OBSERVATION REPORT
Structural Steel

Project:	Park Danforth
Location:	Portland, Maine
Becker Job No:	3422

Observation Location:
 General structural steel observation and pre-slab placement review at Level 3 - west wing.

PLAN OF TYP OPENING IN ROOF & FLOOR DECK
N.T.S.

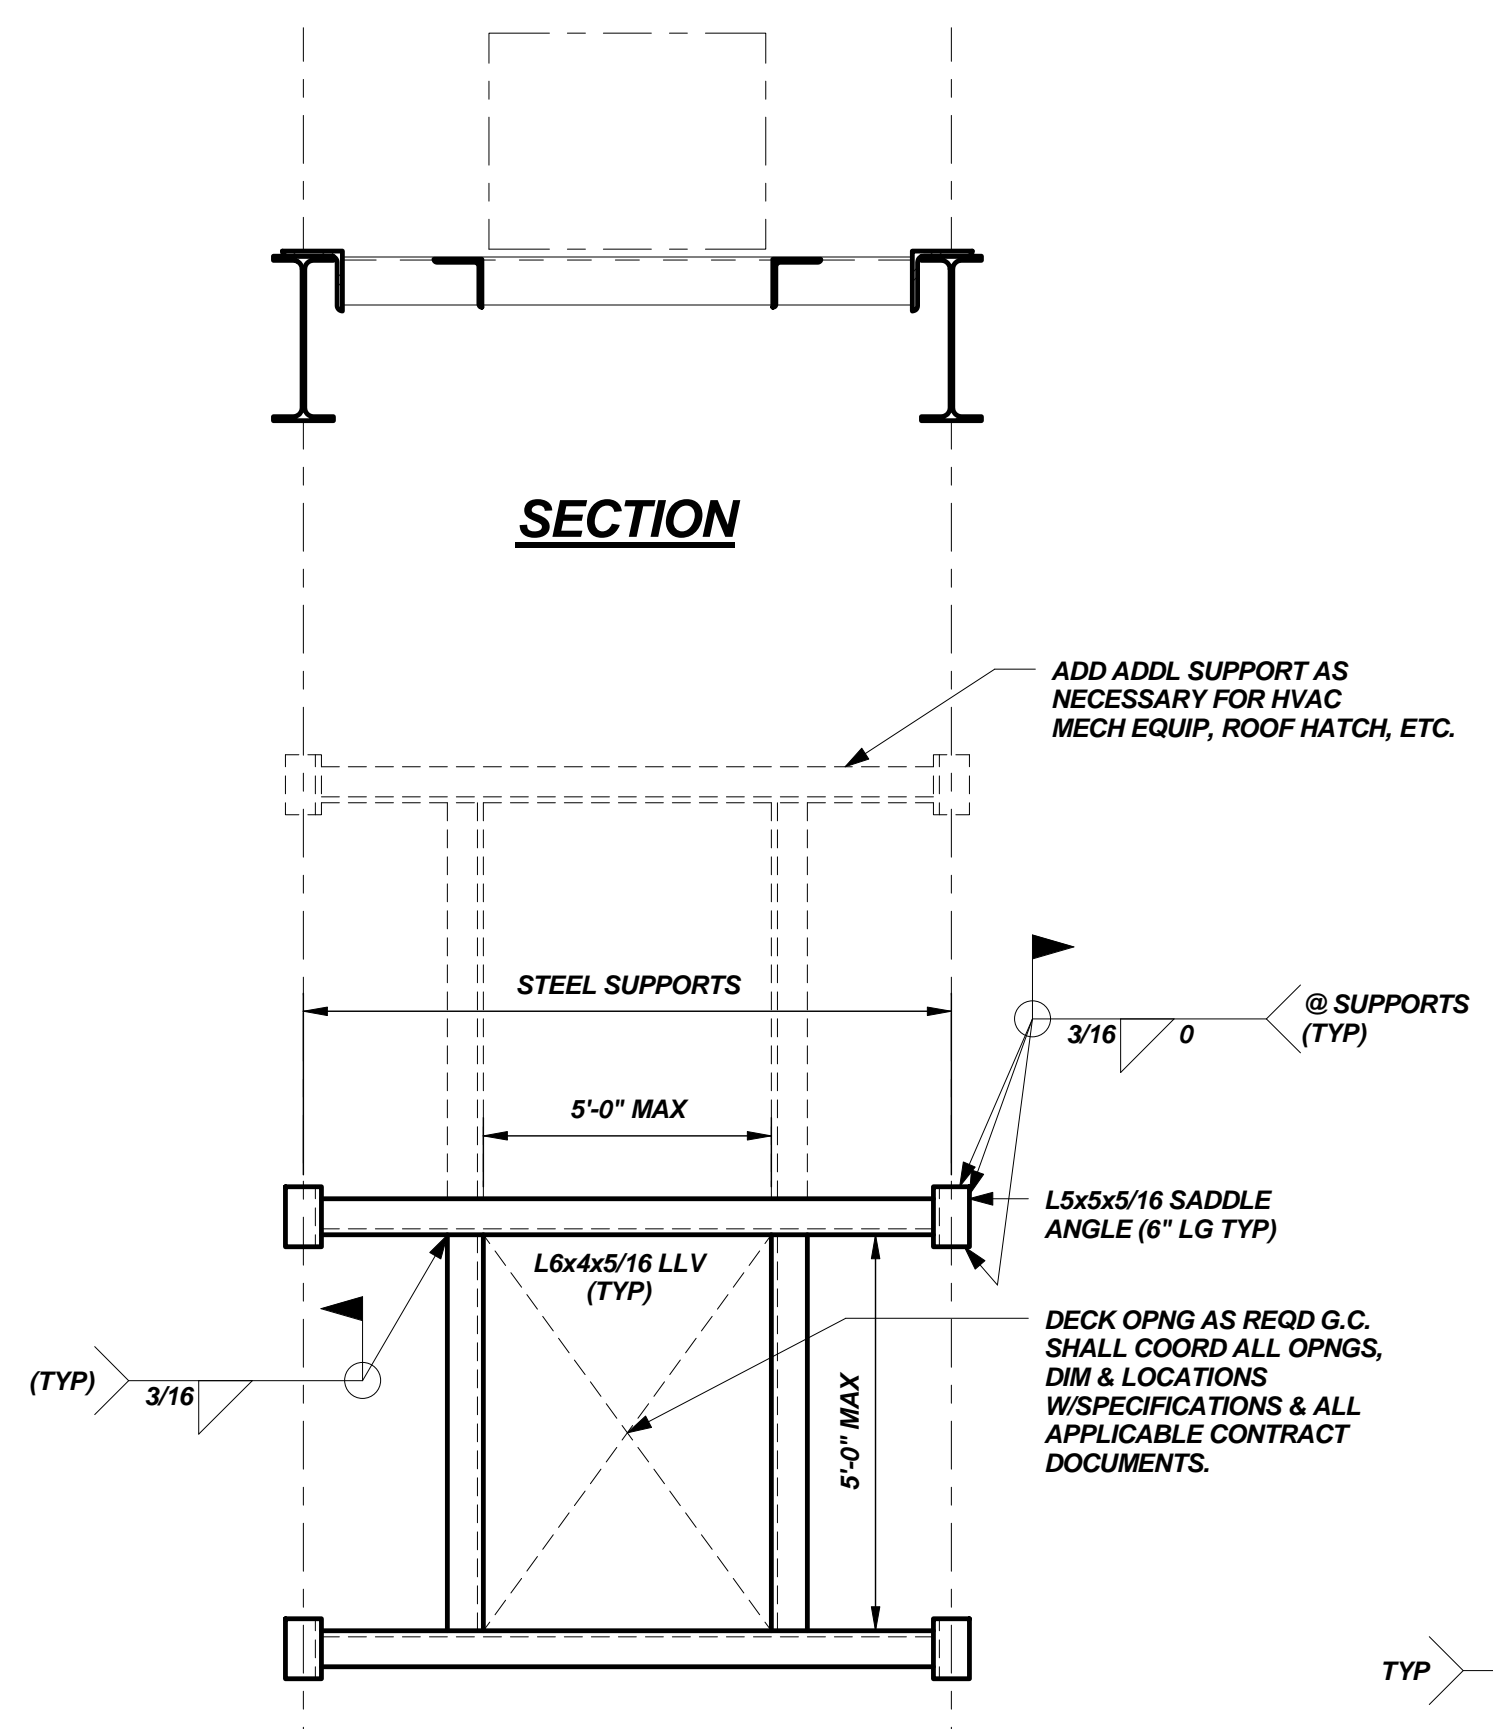
I informed Andrew from PC and the shear stud welder on site that 2 beams around the HVAC floor penetration required additional studs per typical web penetration detail.
